Application number: 2026/91063	
What is the application for?:	Re-instatement and repair of existing building including alterations to roof and
Address of the site or building:	382, Huddersfield Road, Mirfield, WF14 9DL
Postcode:

Type of comment: An objection	
Do you wish your comments to be published on the website anonymously?	Yes
Objection to Planning Application 2026/91063 Site Address: 382, Huddersfield Road, Mirfield, WF14 9DL	
I am writing to formally object to the retrospective planning application for the reinstatement, repair, and alteration of the existing building at the above address. My objection is based strictly on valid planning matters, specifically the severe negative effect on living conditions, highway safety hazards, noise and odour disturbances, and the inappropriate design and appearance of the development. 1. Effect on Living Conditions (Sunlight, Daylight, and Overbearing Nature) Valid planning matters include the effect a development has on the living conditions of neighbours, including the loss of daylight and sunlight. • The original structure on this site was a single-story butcher's shop with a flat, level roof. • The developer has unlawfully demolish

Location & Proposed Site Plan

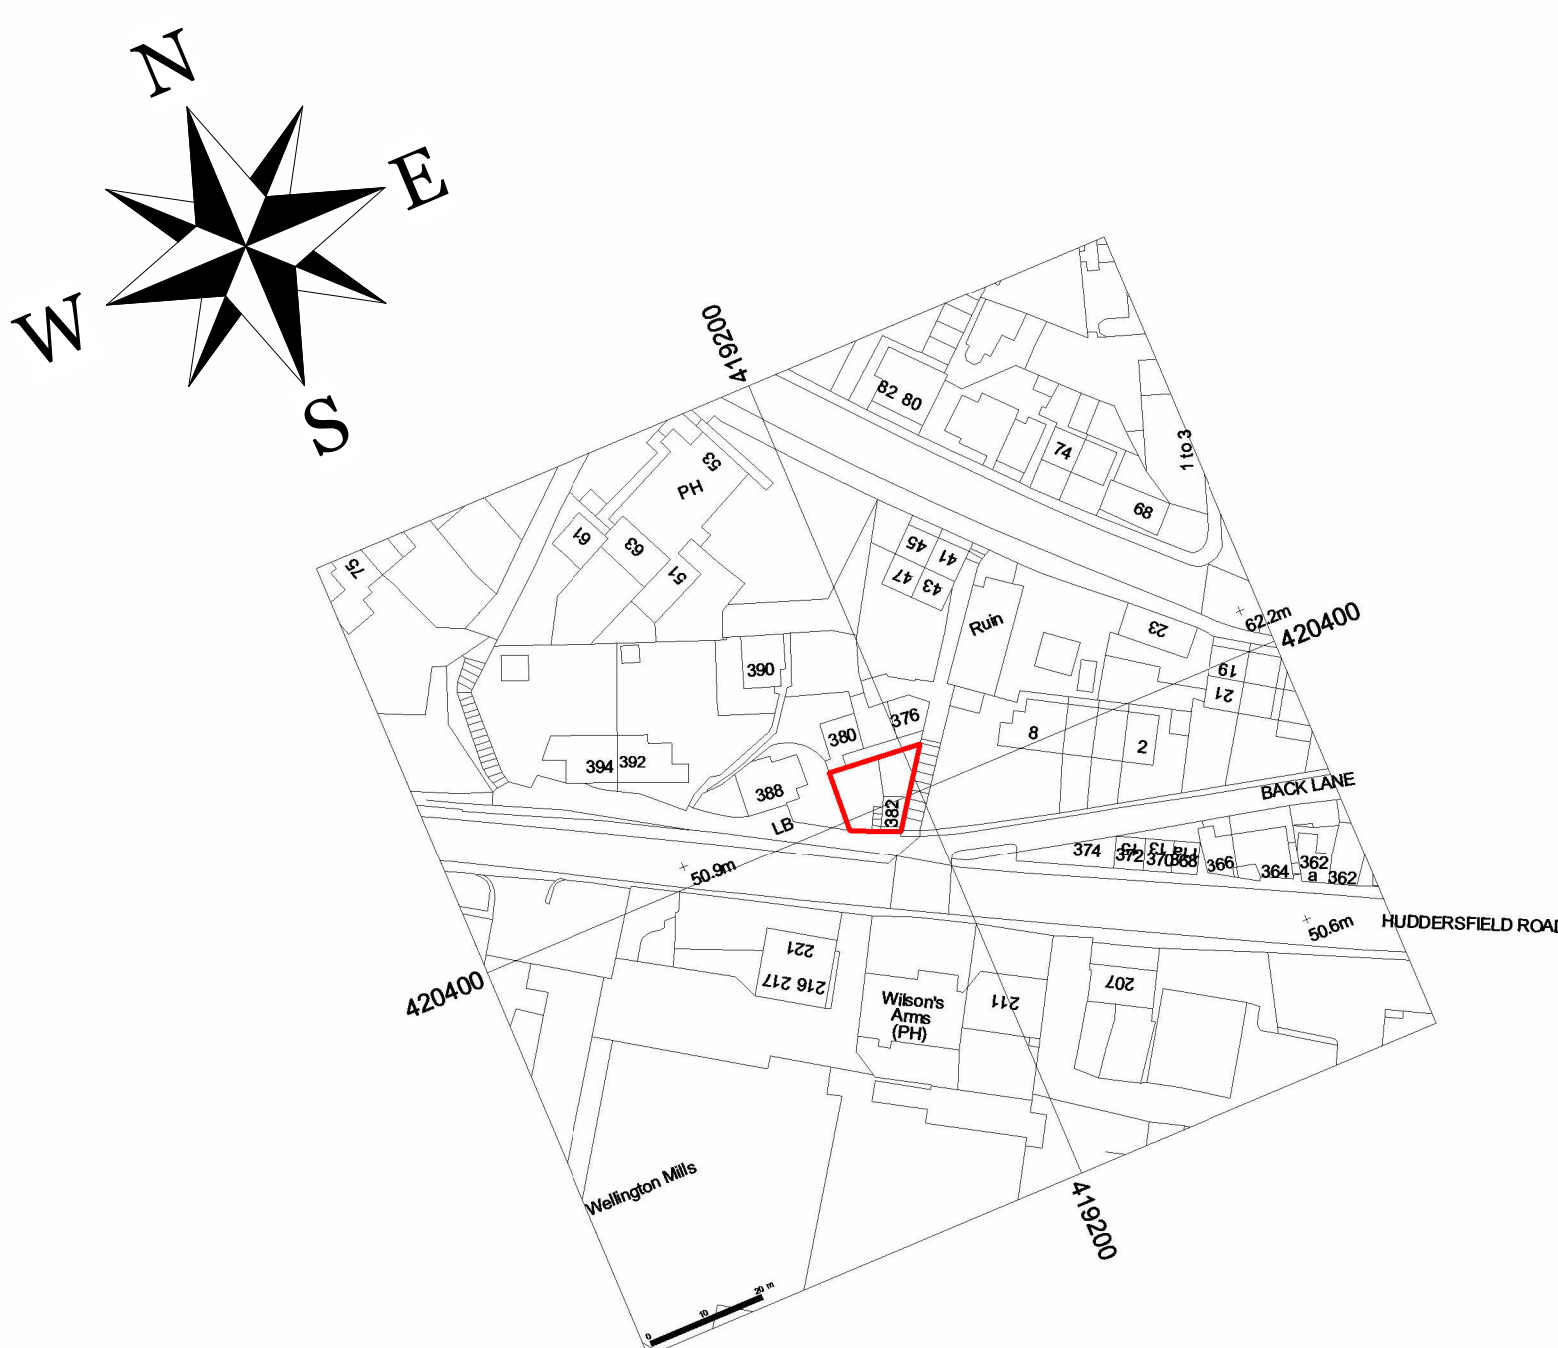
- **Pedestrian and Vehicle Hazard:** The access lane to four neighbouring properties is incredibly narrow, forcing residents to drive up and reverse down. The proposed shop exit introduces a severe blind spot, even with a barrier. If a customer steps out while a resident is reversing, or ties a dog to the barrier whilst visiting the shop, it presents a critical safety hazard. The application fails to ensure the site can be safely entered and exited by all transport modes without causing safety hazards (Policy LP21).

Drawing Title:
Location & Existing Site Plan

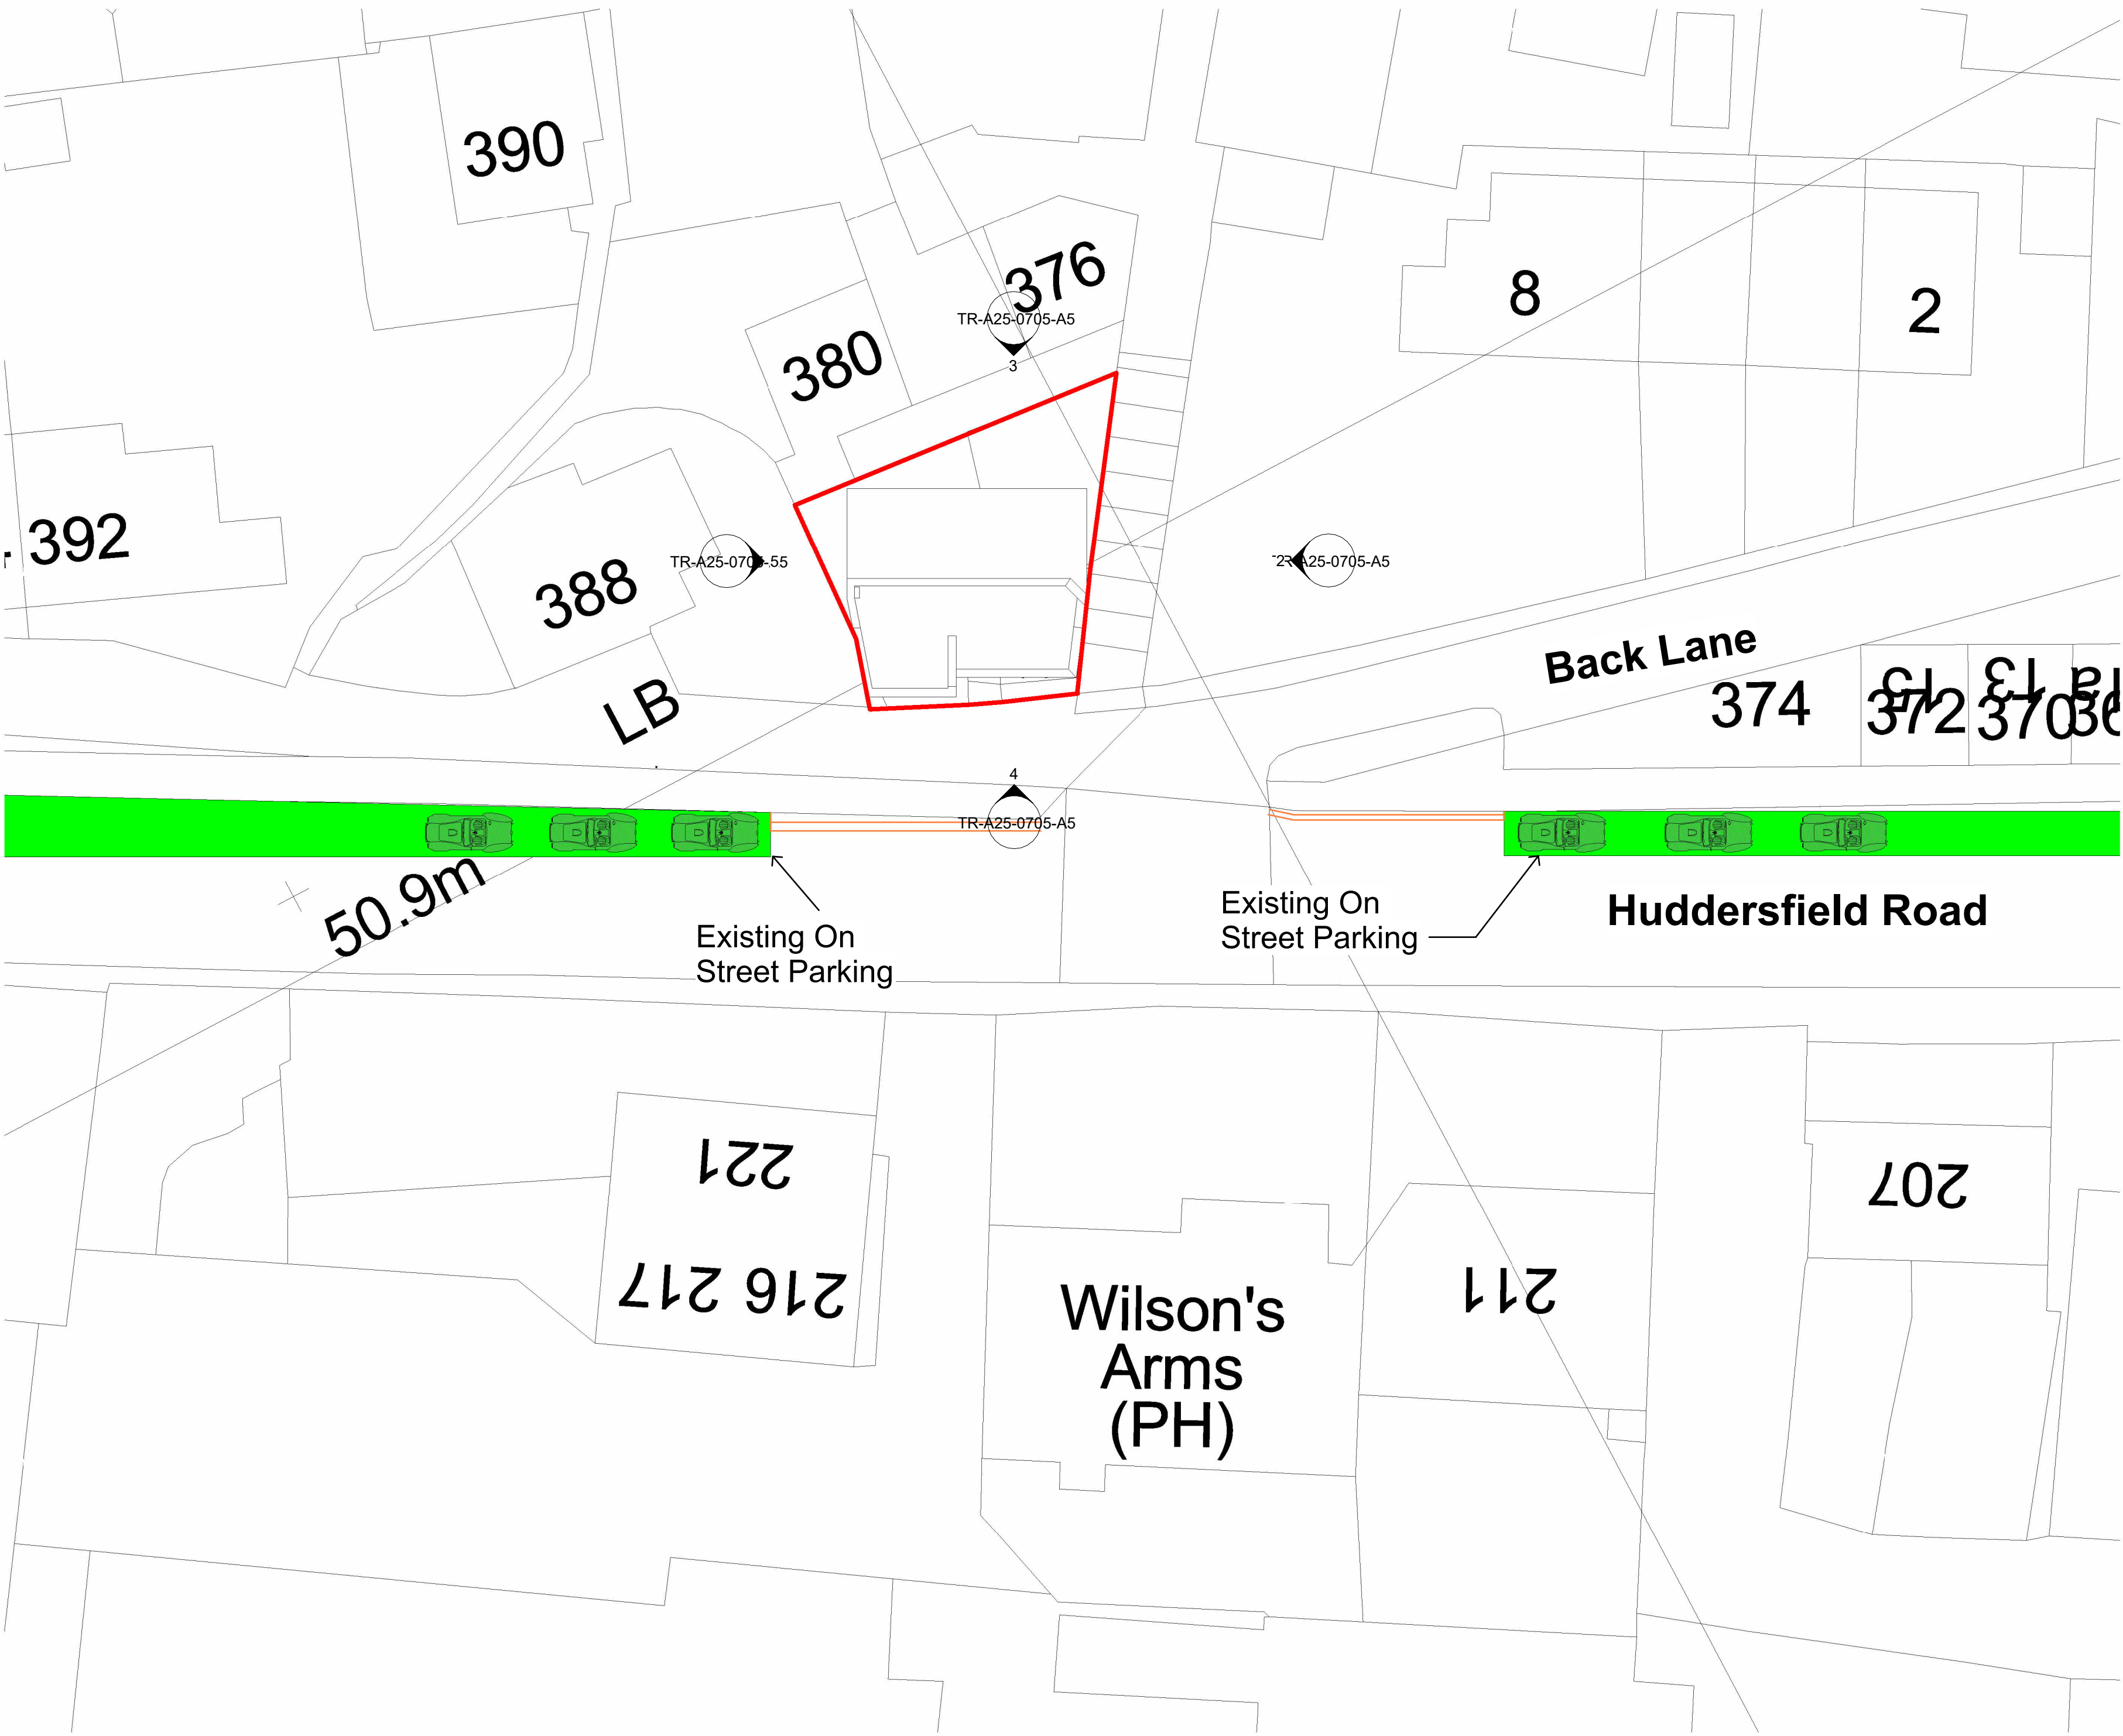
- **Inappropriate Materials:** The application states materials will match or compliment the original stone building. However, the development built thus far relies on stark, exposed concrete breeze blocks which are entirely out of keeping with the aesthetic character of the surrounding area.
- **Misleading Application Data:** The submitted plans contain significant inaccuracies. The actual structure built on-site is taller than the proposed measurements in the submitted drawings, meaning the council and the public are being given a distorted impression of the building's true overbearing impact.
